Accessibility Design Review (DA)

**1 Denison Street,
North Sydney, NSW**

Prepared by:	Angela Chambers
Prepared for:	Victoria Plaza Holdings Pty Ltd
Job No.:	72556
Date:	27 October 2016
Revision:	1.0

Figure 2 Ground floor

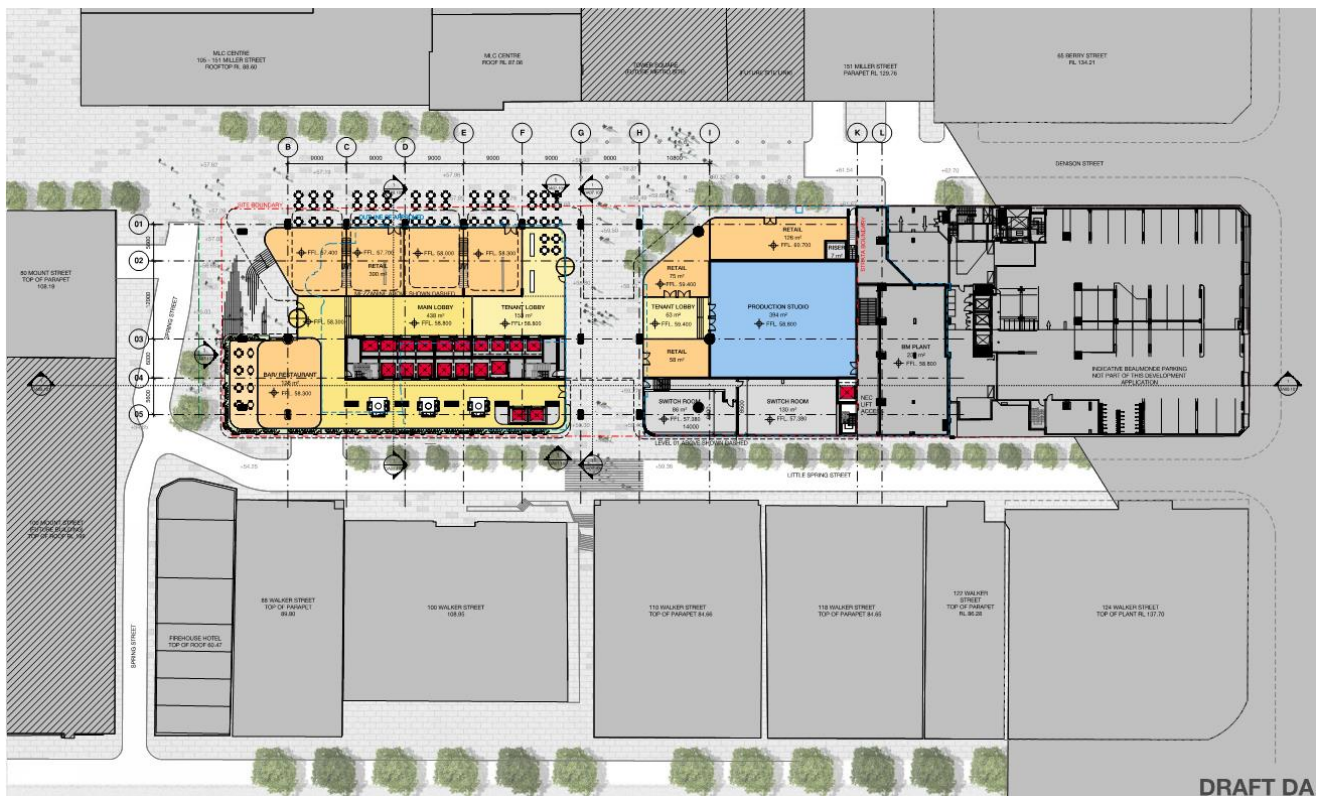
- The design of the stair/ramp entry at Spring Street entry to be further reviewed

Comment/issue	Recommendation	BCA/ DDA	Action
<ul style="list-style-type: none"> A 1:20 ramp and adjacent stair access is provided to the to the Spring Street main entry/lobby This stair/ramp arrangement provides main entry access to Bar/Restaurant at ground level 	<ul style="list-style-type: none"> The ramp and stair are to be designed to comply with AS1428.1-2009 Further review to be undertaken in the next phase of design 	BCA	Capable of Compliance Further detailed information to be provided as the project develops
<ul style="list-style-type: none"> Ensure external paths are of adequate width to accommodate passing and turning spaces 	<ul style="list-style-type: none"> Provide a minimum of 1500mm width to allow a pram and wheelchair to pass Consider a path width of 1800mm to allow two wheelchairs to pass, particularly to the public realm Minimum width must be measured clear of bollards or fixtures 	BCA	Compliance indicated
